CITY OF ALBUQUERQUE

RE: **Chipotle**
4930 Pan American Fwy NE
Grading and Drainage Plan
Engineer's Stamp Date: 9/25/2018
Hydrology File: F17D101

Based on the submittal received on 10/1/18, the Grading and Drainage Plan cannot be approved for Grading or Building Permit until the following corrections are made:

C
201

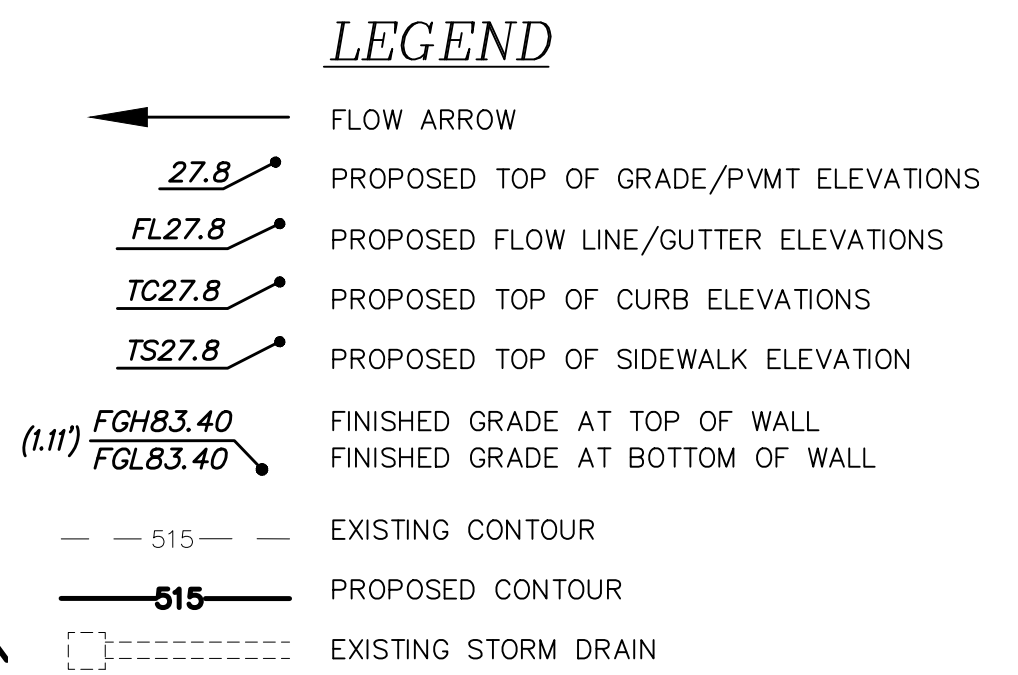
1. For trash enclosures serving food service developments, demonstrate control of liquids from dumpster areas per DPM Chapter 22.9.E, Table 1 by containing runoff from the dumpster area and discharging to the sanitary sewer. If this information is on the utility plan please provide it, or show on the grading plan.

2. Quantify the additional impervious area and new first flush volume being generated by this project.
3. A portion of this project is located in a floodplain (AO-1') and a floodplain permit must be obtained. Please contact Rudy Rael, CFM for more information regarding floodplain permits (RRael@cabq.gov).

4. How much fill/cut is being placed in the floodplain?
5. For Information. Hydrology and Transportation files are available online through the City's GIS Viewer 2.0: <https://www.cabq.gov/gis/advanced-map-viewer>. Turn on the *HydroTrans* layer: *Operational Layers > Albuquerque Layers > Sites > HydroTrans*. Select the desired polygon from the map and click *Link to Project Documents*.
